## Engineers Comments Regarding Surface Water Drainage

| <b>Application Reference:</b>   | LU/185/25/DOC                                                                                                                                                                                                                                                                                                                                                                                                                                                         | <b>Reviewer Reference:</b> | ADC/EXT2/D2134/83 |
| <b>Site Name:</b>               | Land West of Holly Drive Littlehampton                                                                                                                                                                                                                                                                                                                                                                                                                                |                            |                   |
| <b>Application Description:</b> | Approval of details reserv

SCALE AT A1:	DATE:	DRAWN:	CHECKED:	APPROVED:
NTS	27.06.2025	SRV	VPI	VPI
PROJECT NO:	DRAWING NO:	REVISION:		
519	519.1.VCE.0505	T2

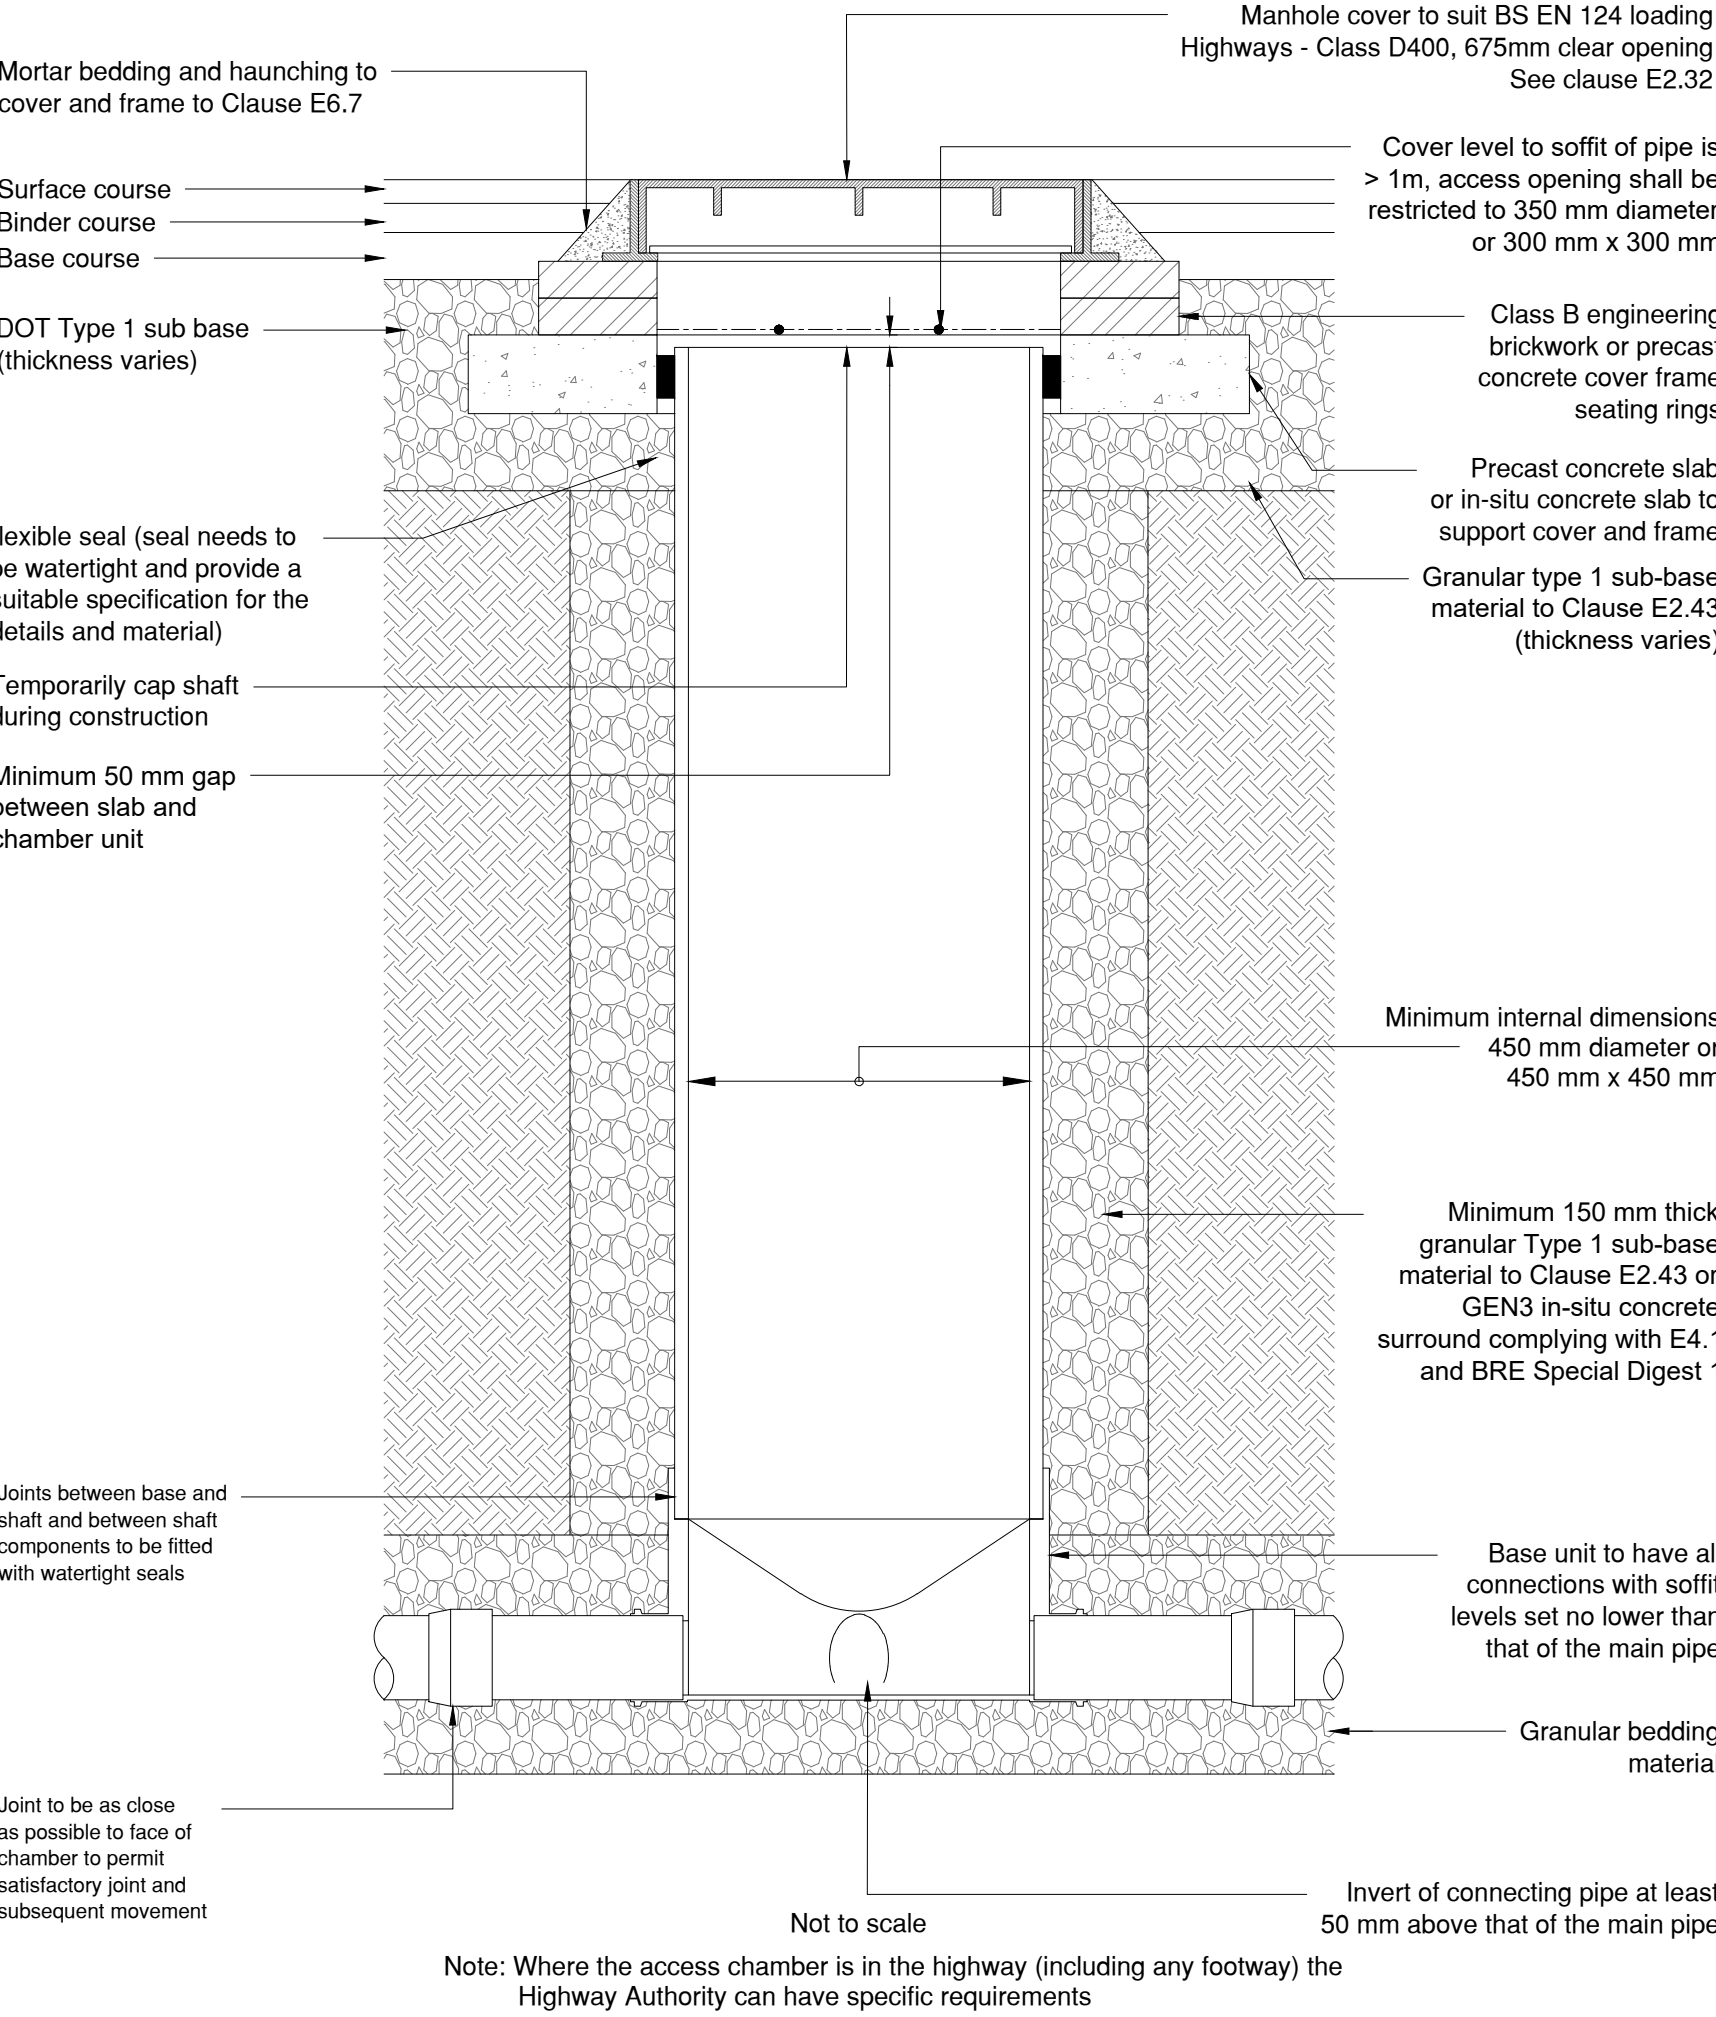
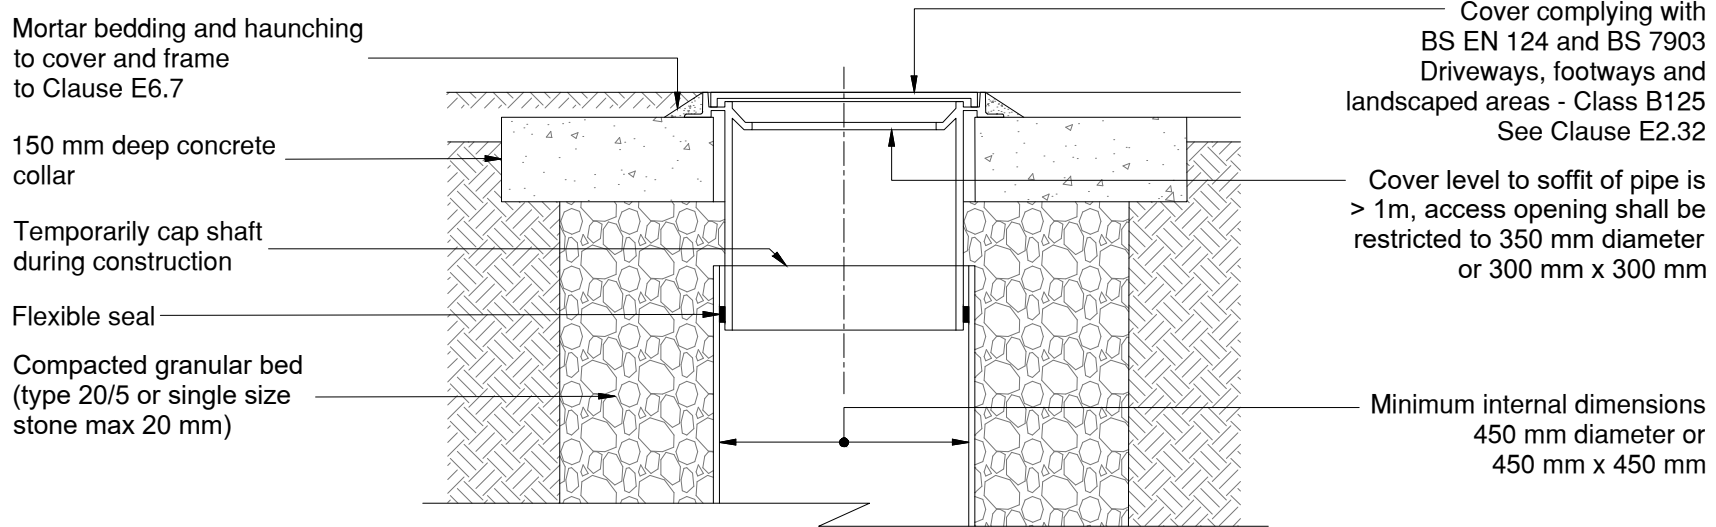
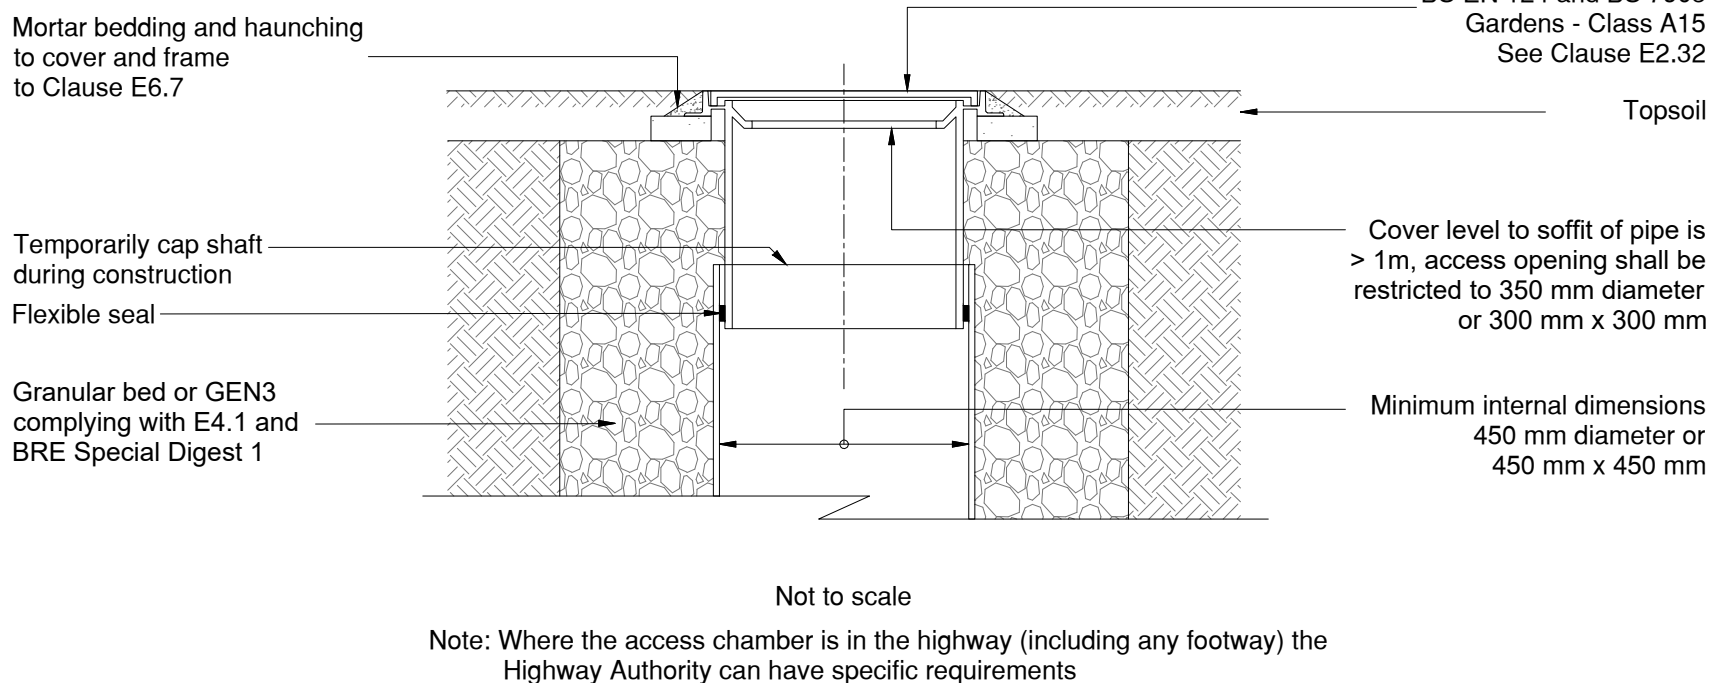
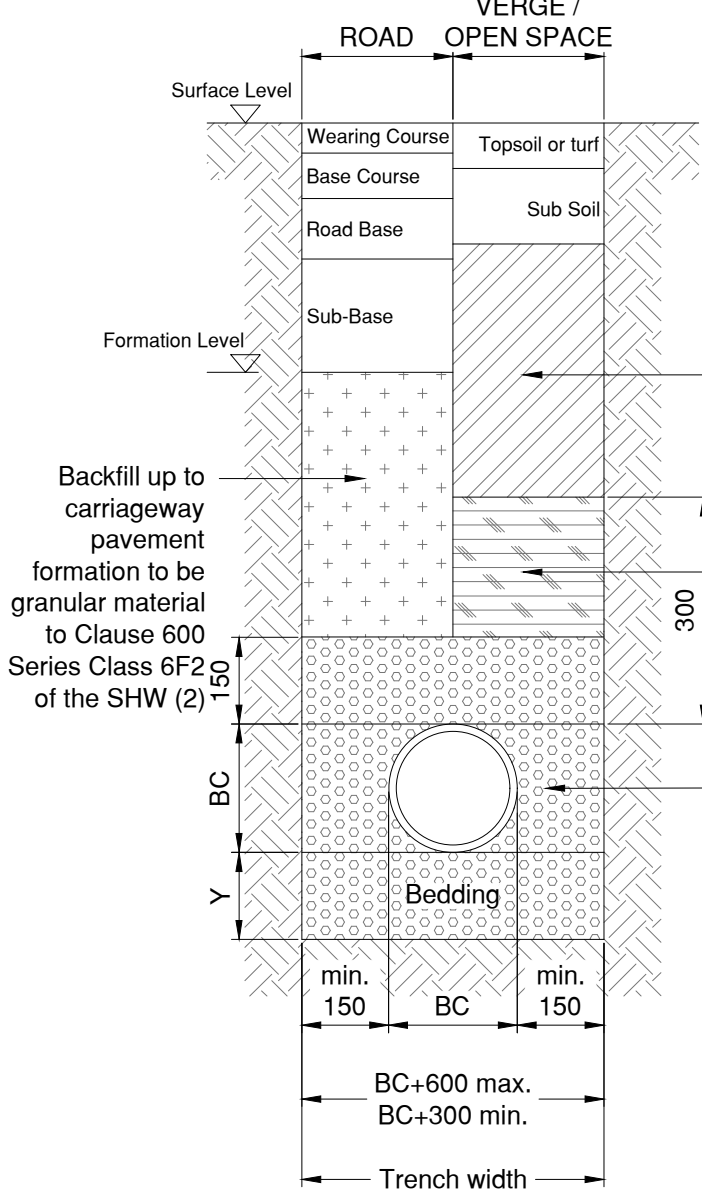
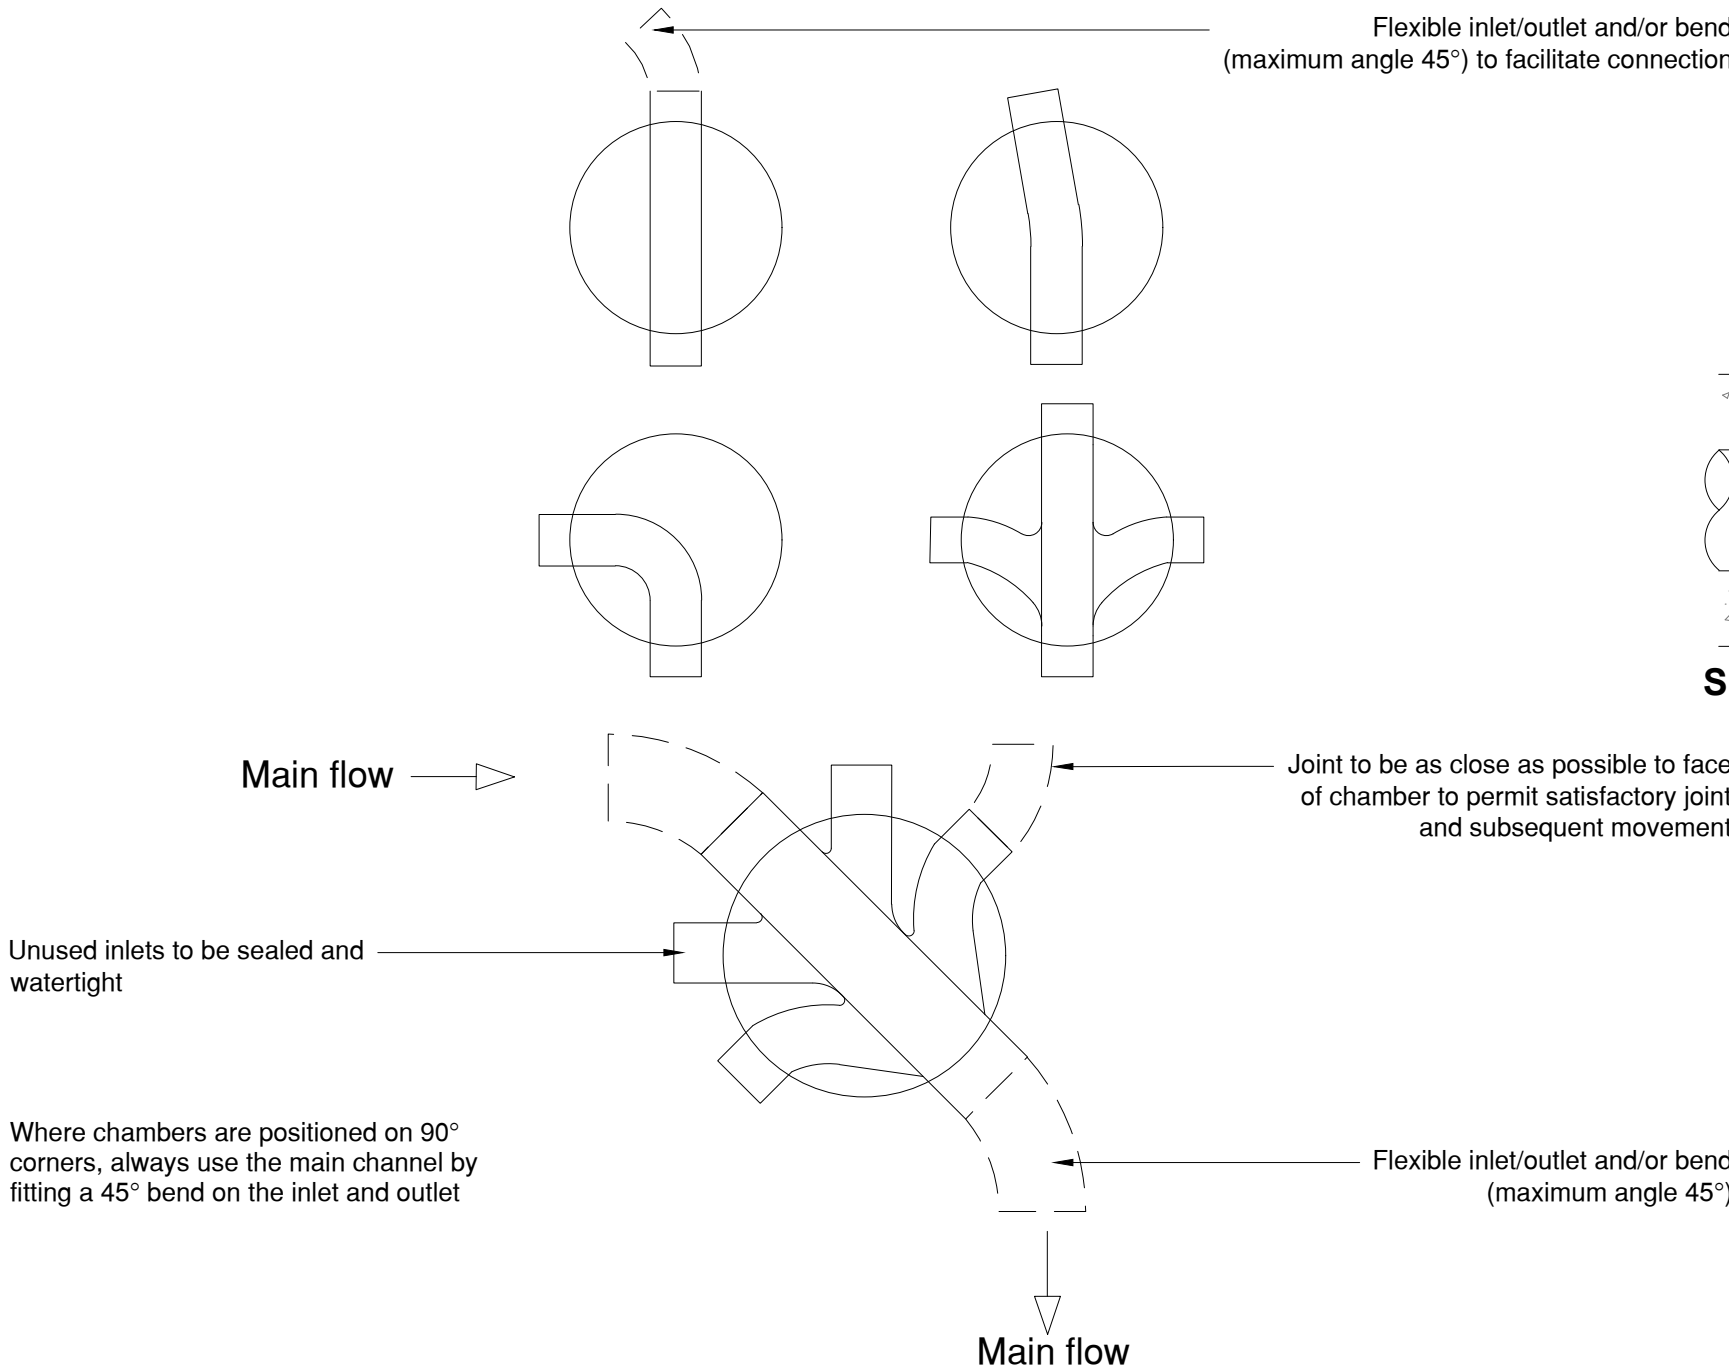
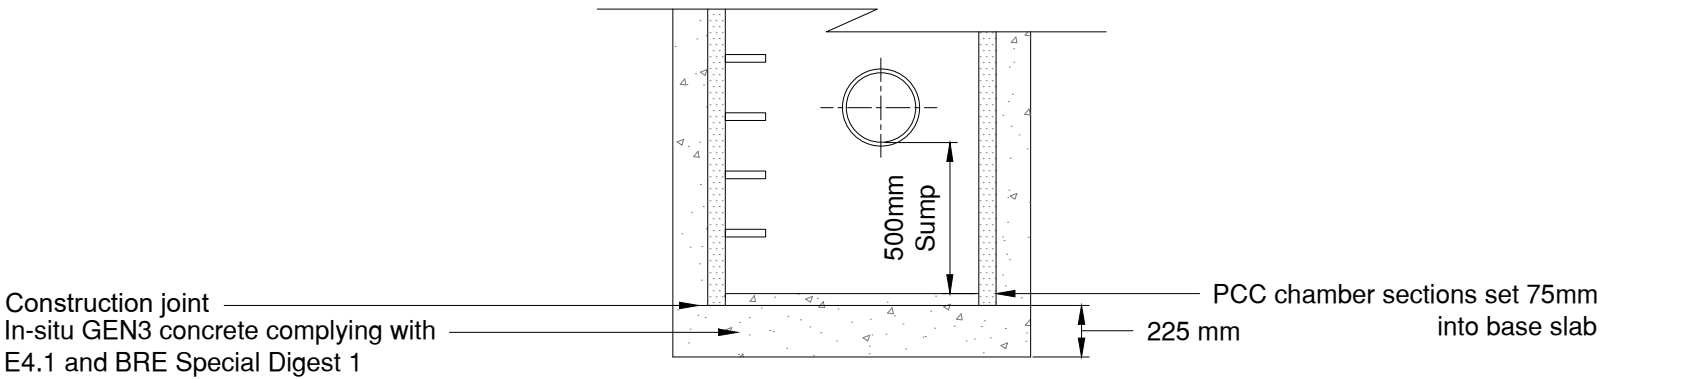
| 13 | Construction details sheet 1 shows a type B manhole which is not used, please remove any details not relevant to the scheme.                                                                              | Catchpit Manhole <b>S1</b> has been specified as a <b>Type B</b> manhole with a <b>500mm</b> deep sump.                                                                                                                                                                   | Comment closed. |  |  |
| 14 | Please include a standard detail for the PCC ring catchpit and qualify the base sump depth.                                                                                                               | Please refer to drawing: <b>519.1.VCE.0505</b> for details of the <b>Type B</b> manhole with a <b>500mm</b> deep sump.                                                                                                                                                    | Comment closed. |  |  |
